**Consultation Response from KC,
Highways Development Management**

2024/93155 former Conservative Club, Stocks Lane, Batley, WF17 8PA

Change of use from conservative club to retail, cafe (hot food), external alterations to form covered seating area and accessible entrance to the main entrance, erection of extension to form two retail units and plant room (within a Conservation Area)

Date Responded: 10-4-2025.

DRAWING TITLE
PROPOSED SITE LAYOUT

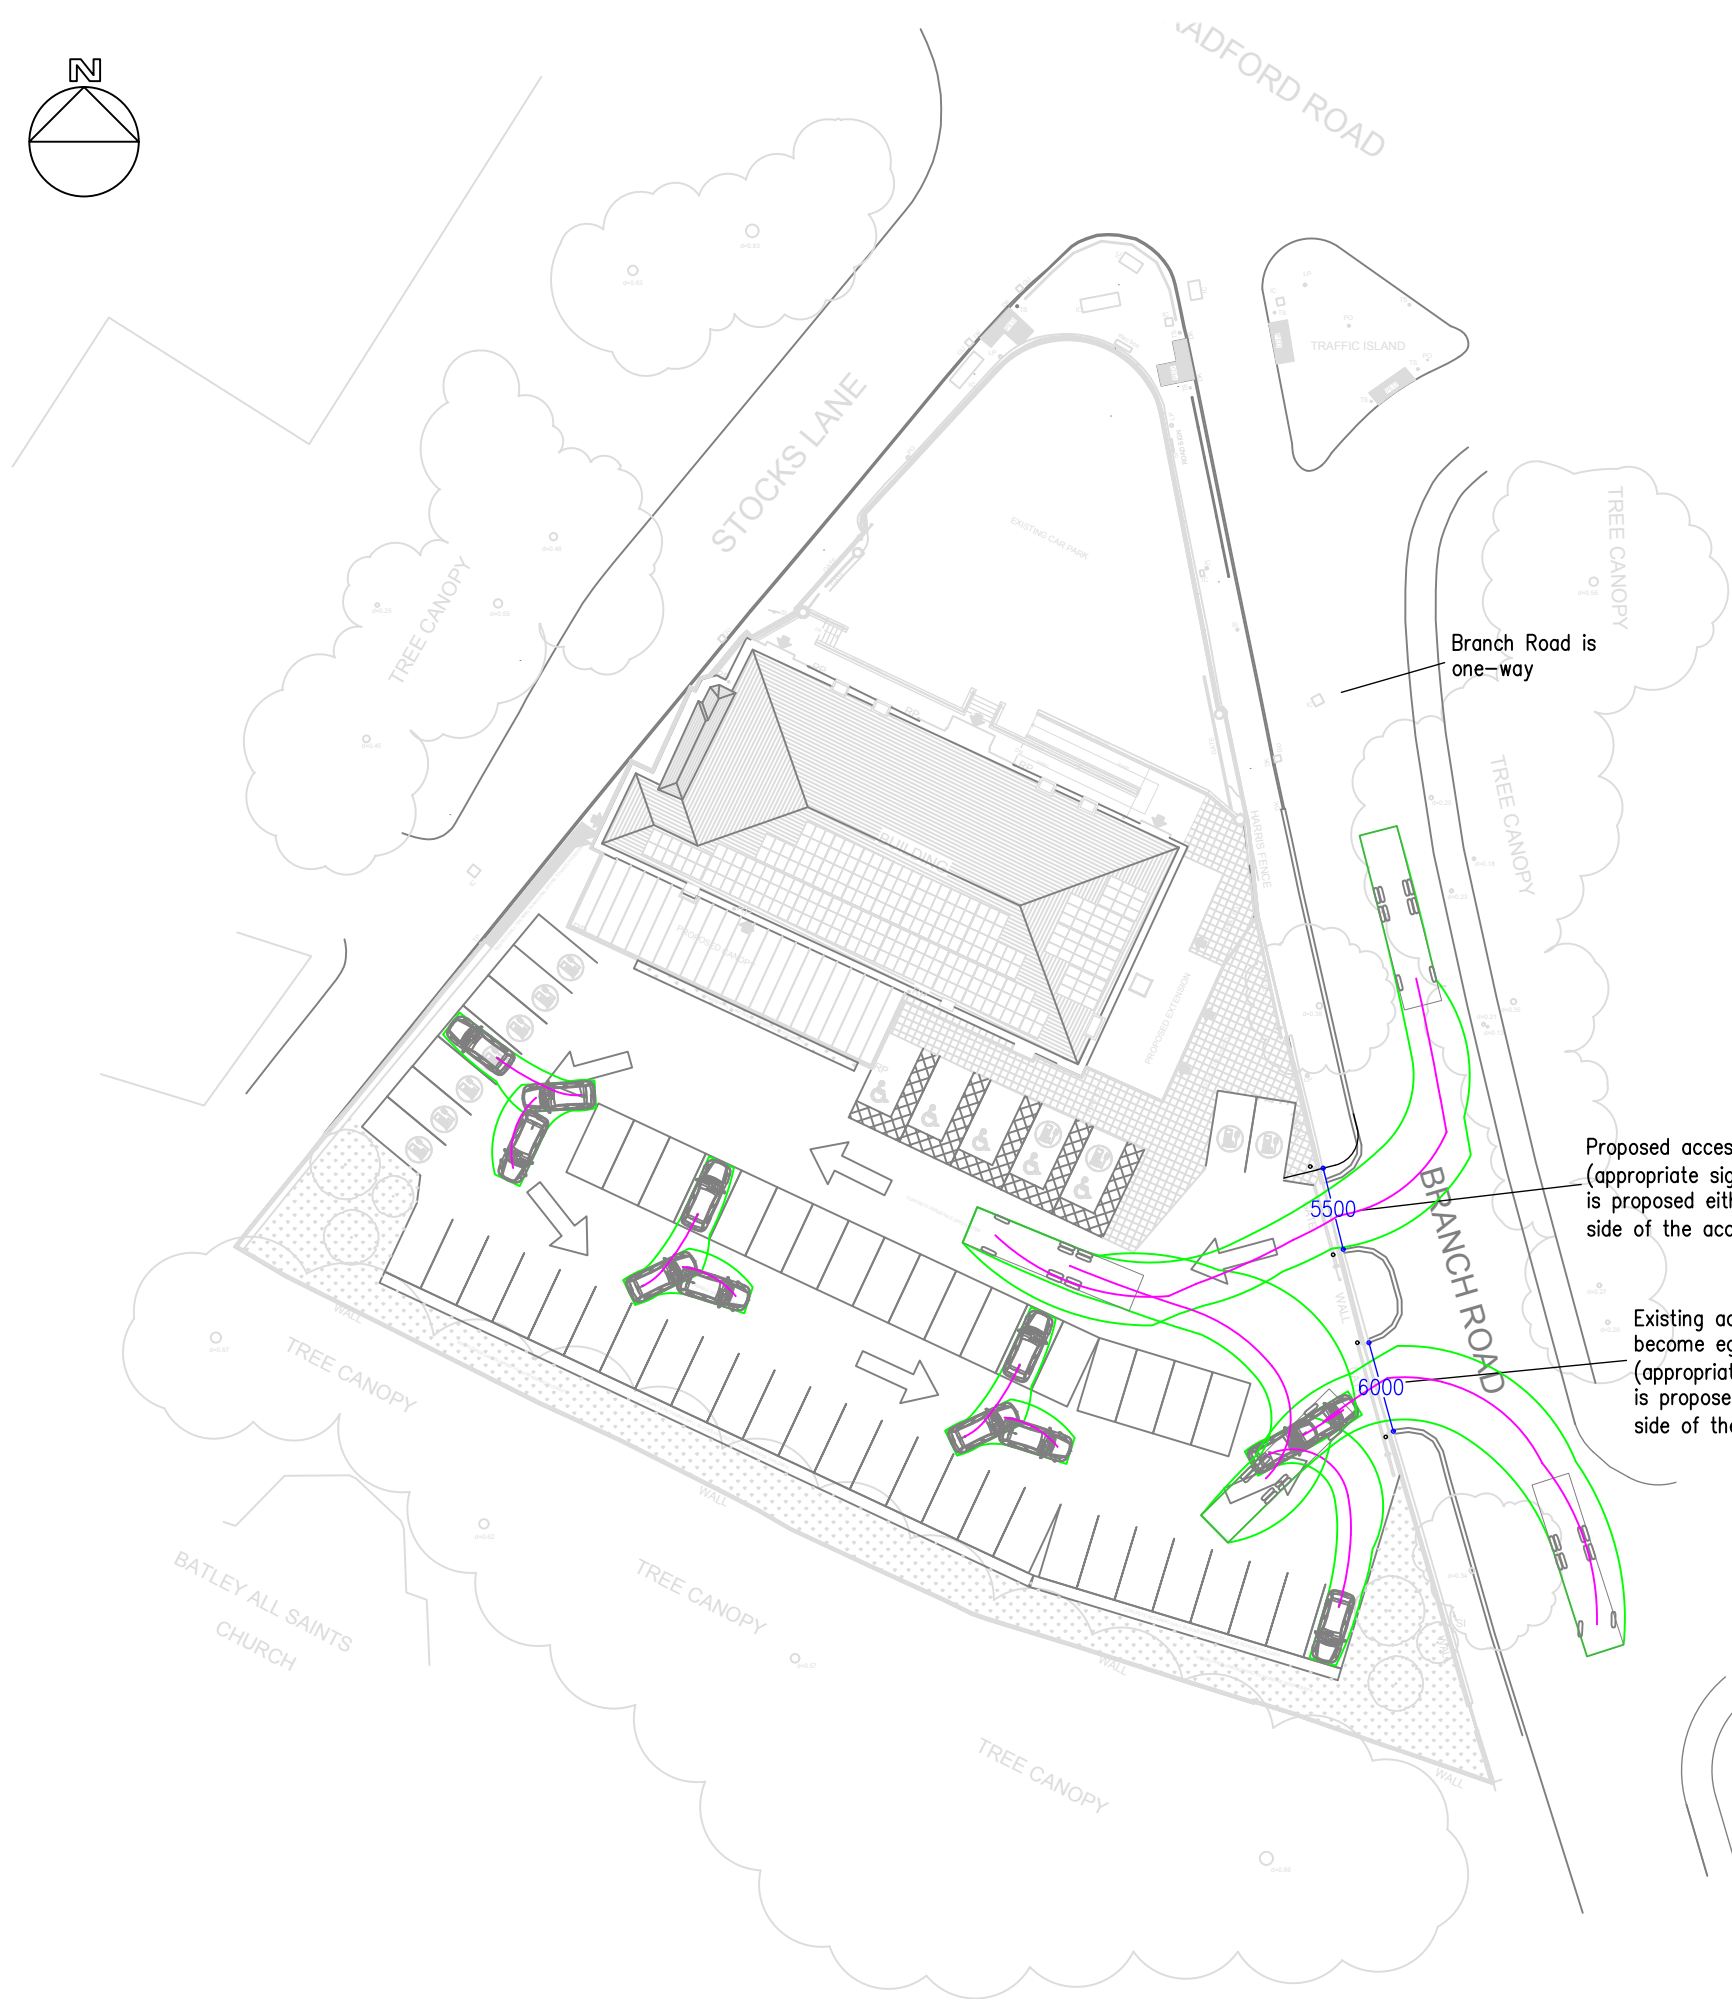
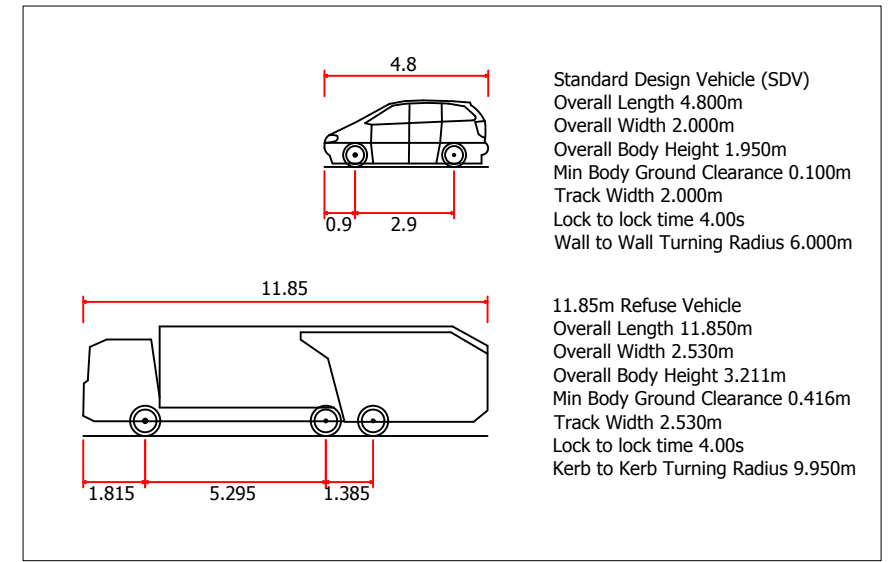
Given the sensitive location of this site on the highway network at the Branch Road/Stocks Lane/A652 Bradford Road junction and to enable H D M to make a proper and meaningful assessment the application should include a Transport Statement prepared in accordance with guidance in the Planning Practice Guidance Suite. The scope of the Transport Statement should be agreed with HDM, and could include details of proposed traffic generation, access to site by various travel modes, accident analysis, a justification of parking standards and site access design and service arrangements.

The proposed change of use will inevitably create a strong desire line across Branch Road between the site and Aldi. Whilst it is acknowledged that the road is one-way it is around 8.5m wide and pin straight, so it could be difficult to cross during busier traffic conditions, especially if less able. Highway Safety would recommend buildouts down to a 5.5m pinch point, with an uncontrolled crossing including appropriate dropped kerbs and tactile paving. Pedestrian access through the boundary should ideally tie-in with the crossing. The Aldi access will need to be shown together with existing waiting restriction which may need to be extended.
